CITY OF ALBUQUERQUE

March 7, 2023

RE: Sawmill Tract H, 1921 Bellamah Ave. NW
Grading & Drainage Plan
Engineer's Stamp Date: 1/4/2023
Hydrology File: J13D017B

1921 BELLAMAH AVE NW ALBUQUERQUE, NM	DRAWN BY pm
	GRADING PLAN	DATE 3-23-23
	 5571 MIDWAY PARK PL NE ALBUQUERQUE, NEW MEXICO 87109 (505) 858-3100 www.tierrowestllc.com	SHEET # GR-1
		JOB # 2022047

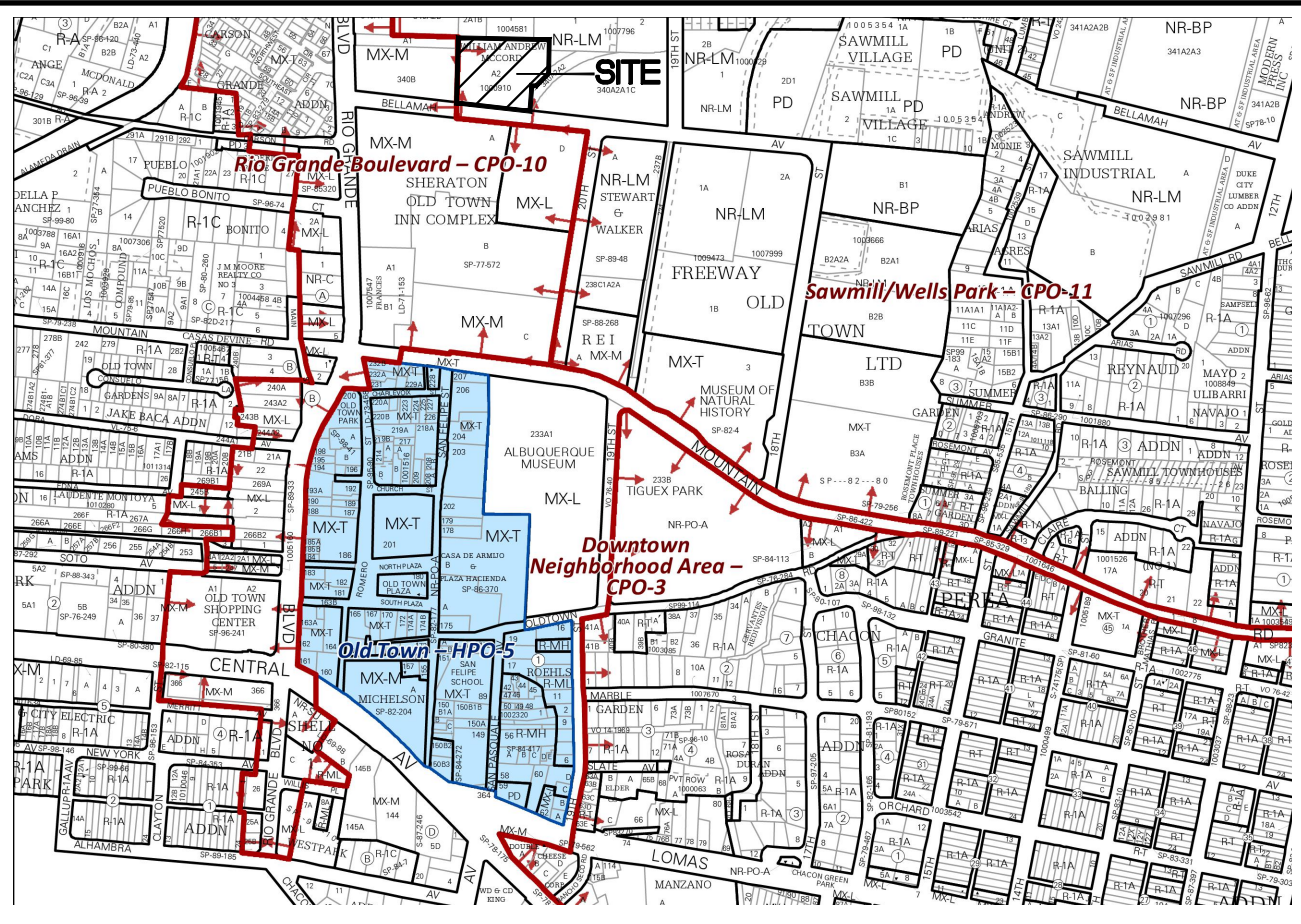
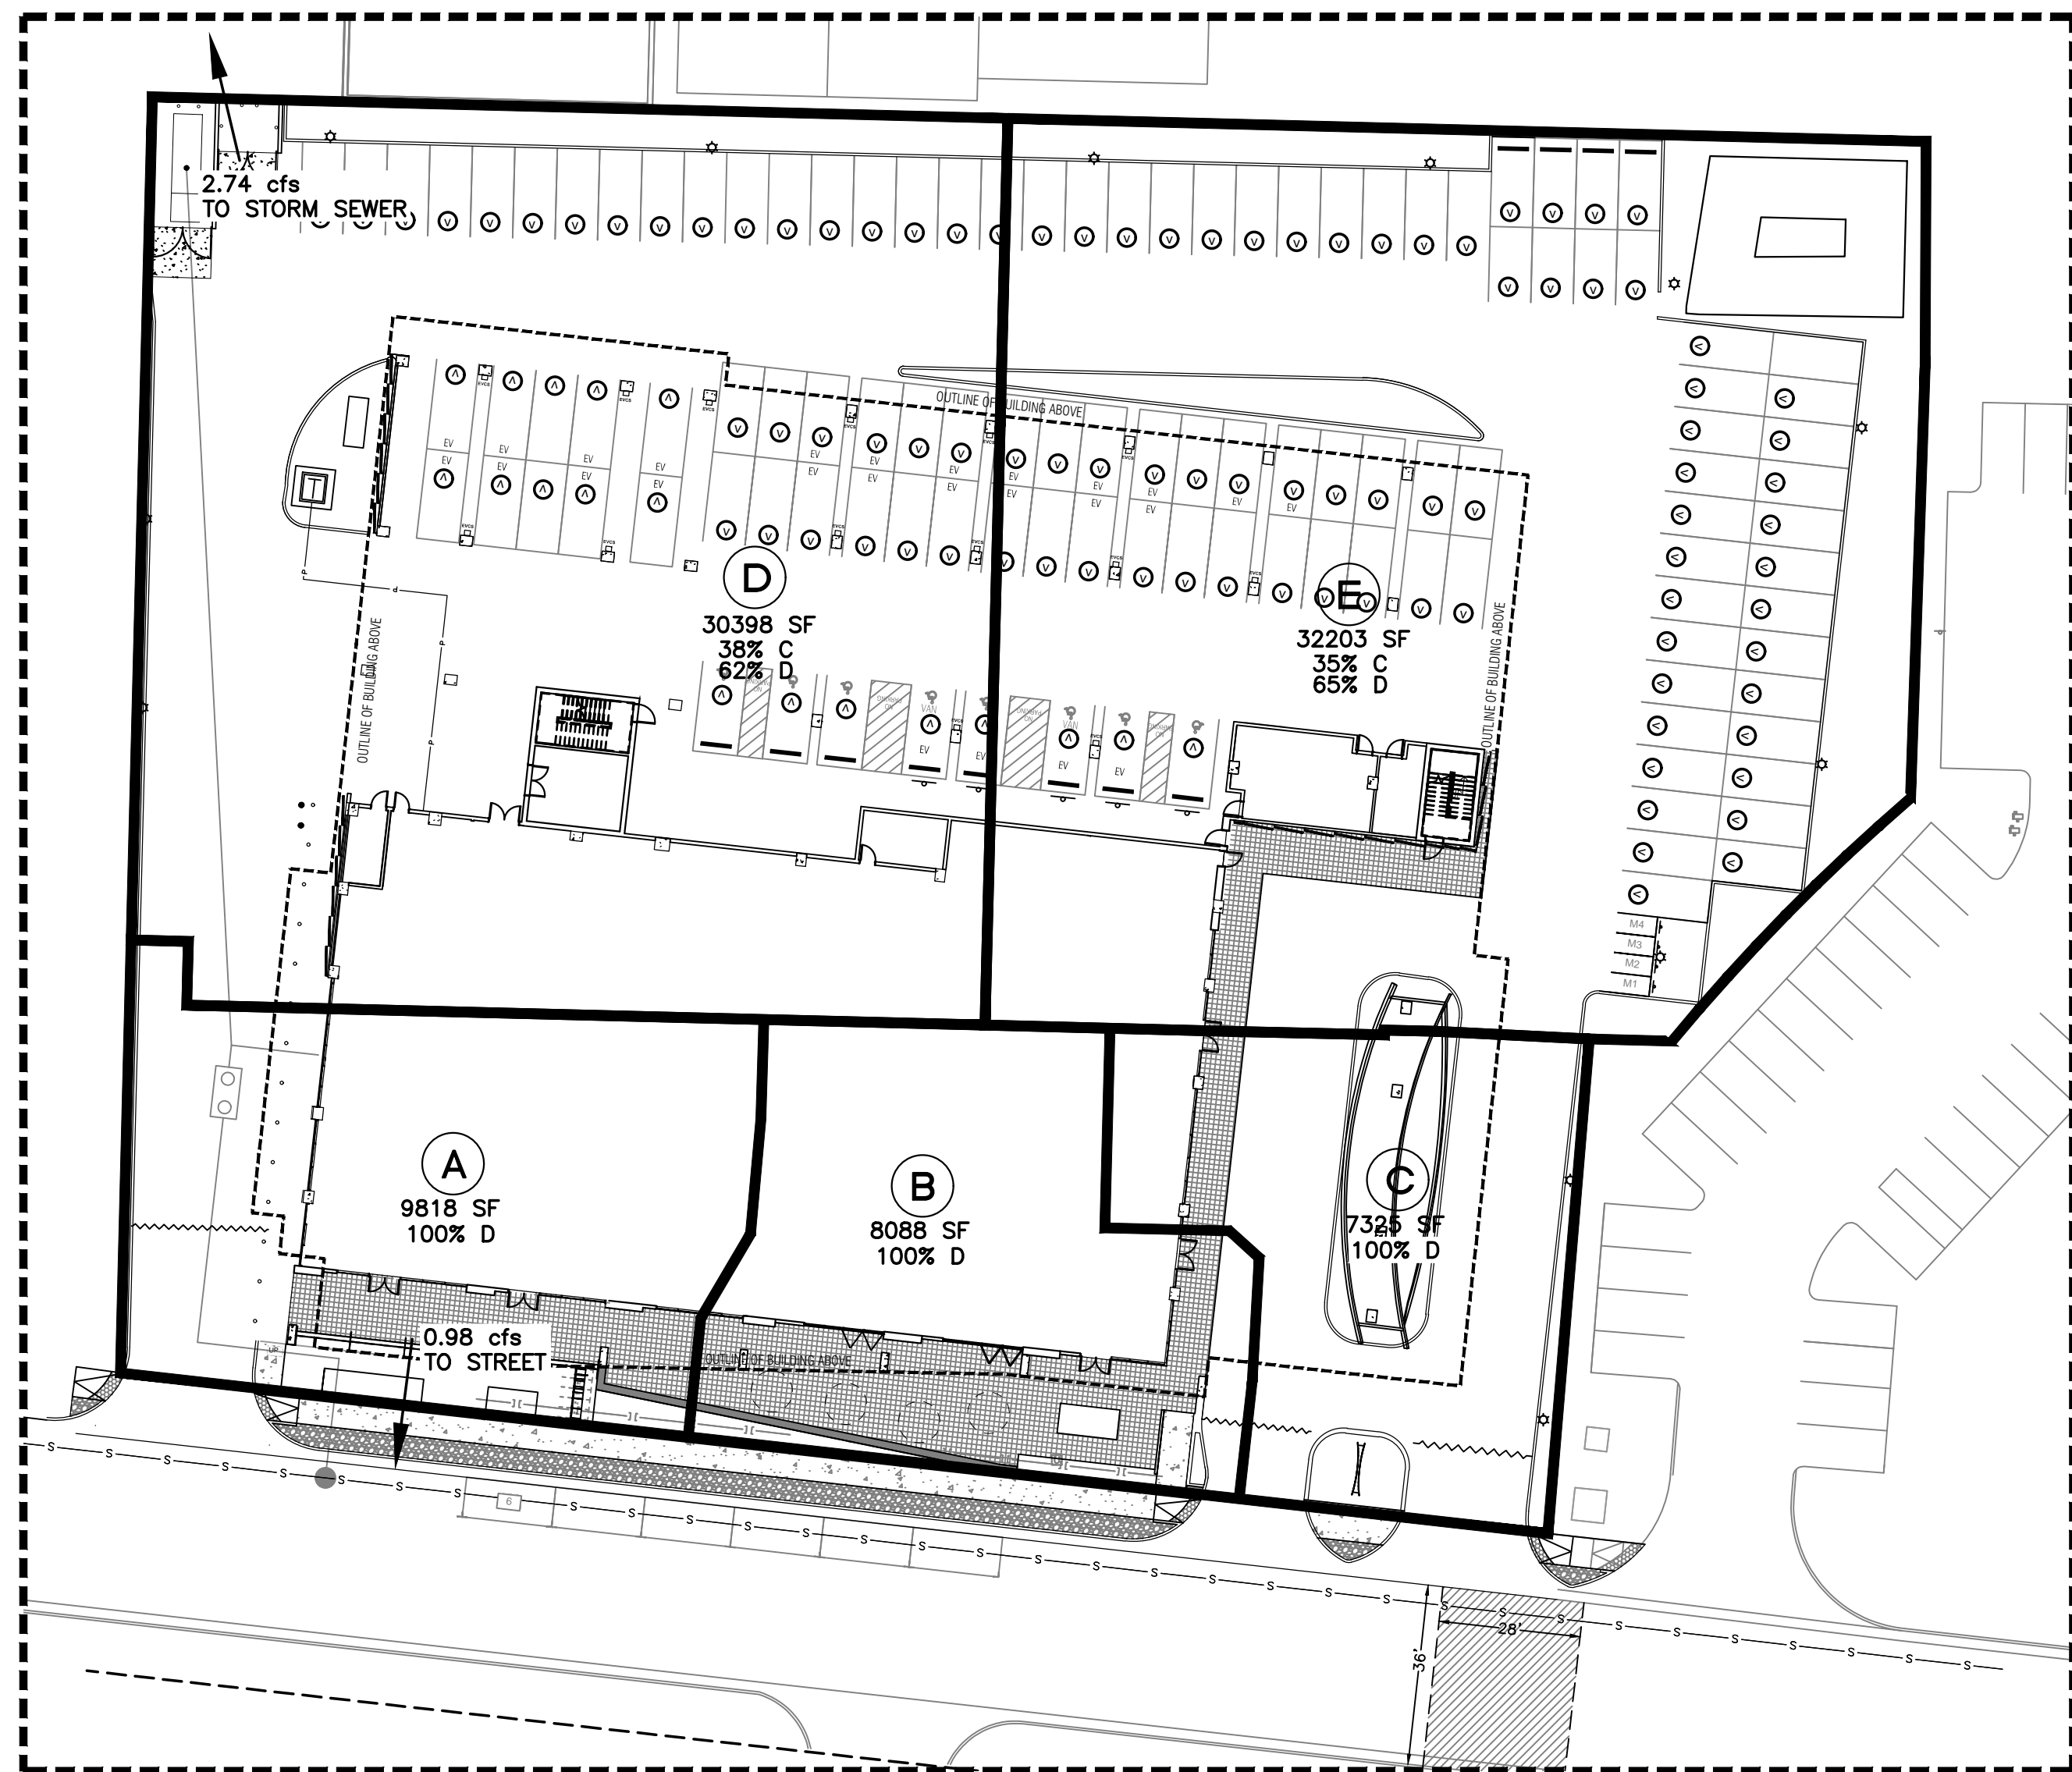
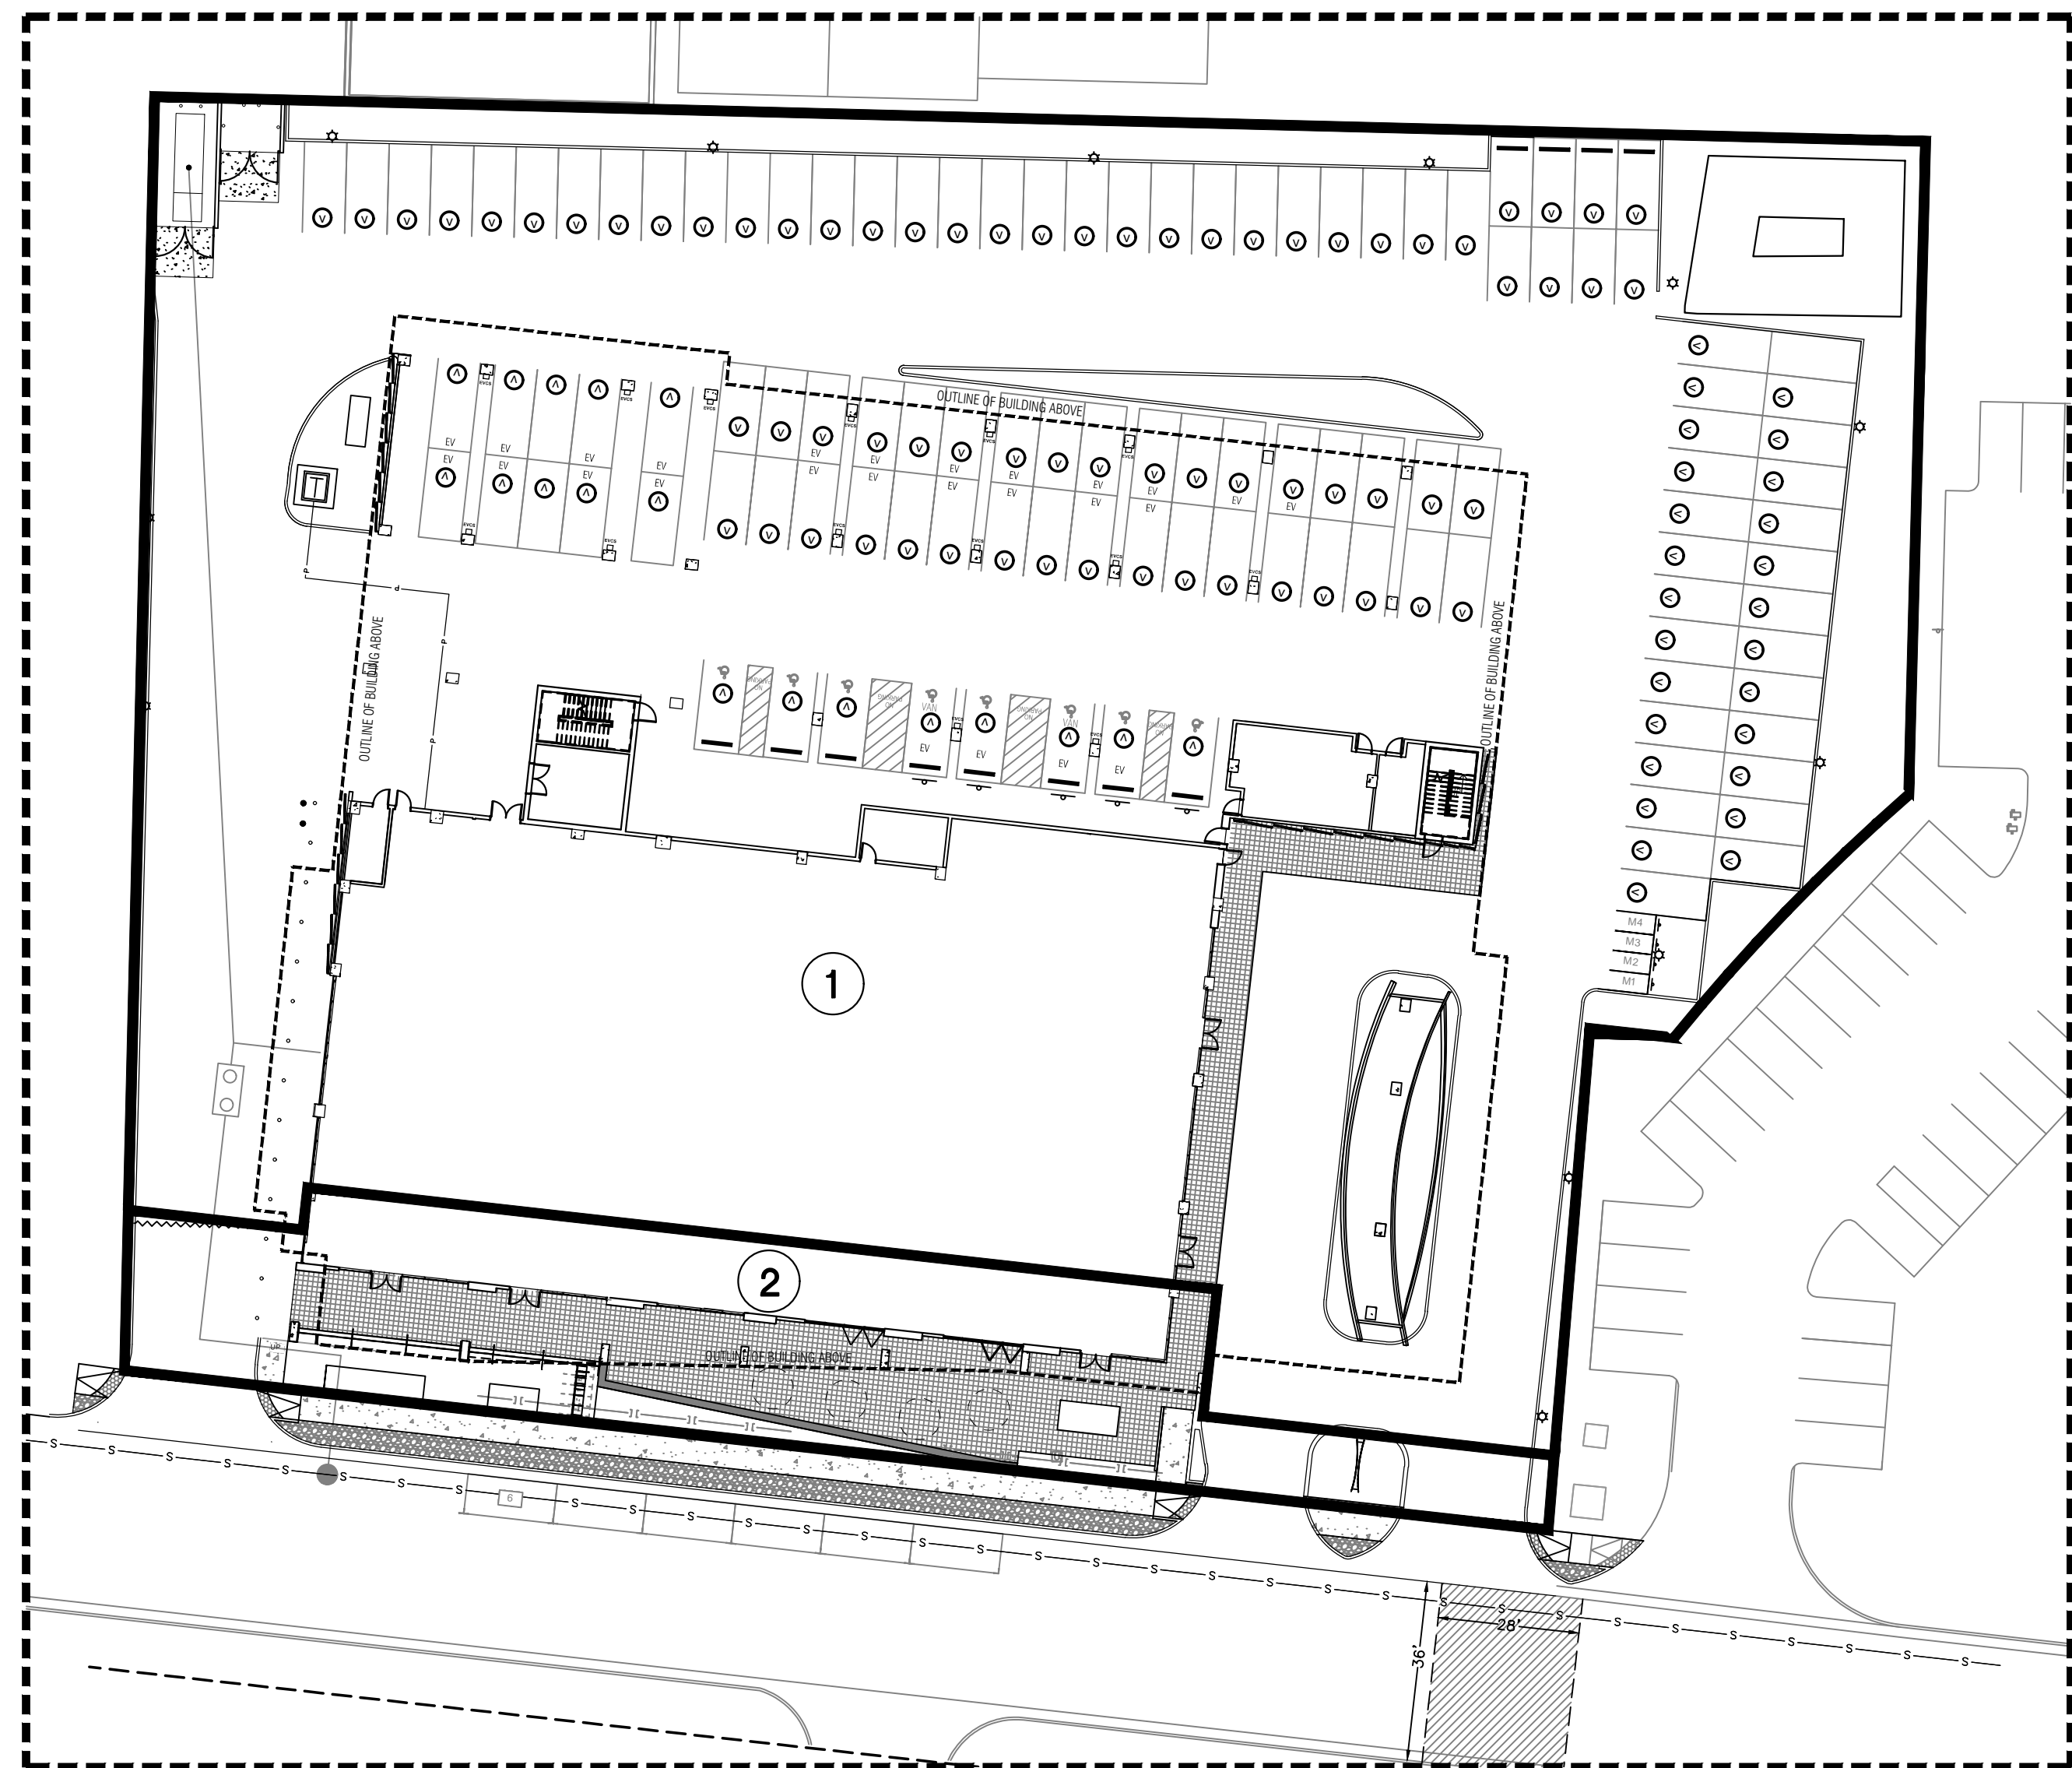
1. Please provide pond 2 location, volume and cross-section on sheet #GR-1.
2. Show the bioswale for proposed basin 1.
3. On sheet #GR-1, Proposed Drainage: It states that "The pond in basin 2 will retain the developed runoff of 0.036 ac-ft which is less than the required water quality volume of 0.40 ac-ft". – This statement is confusing. First of all, the retention pond volume should not be less than the SWQV. Secondly, would pond 1 volume be counted for part of the SWQV? Please clarify. Also, the required SWQV is 0.04 ac-ft, not 0.40 ac-ft. This might be a typo.
4. On the same sheet: The next sentence states that "The pond will drain 7.15 cfs. Therefore the total discharge from the site will be 8.09 cfs". – Please provide calculations showing that where these number come from.
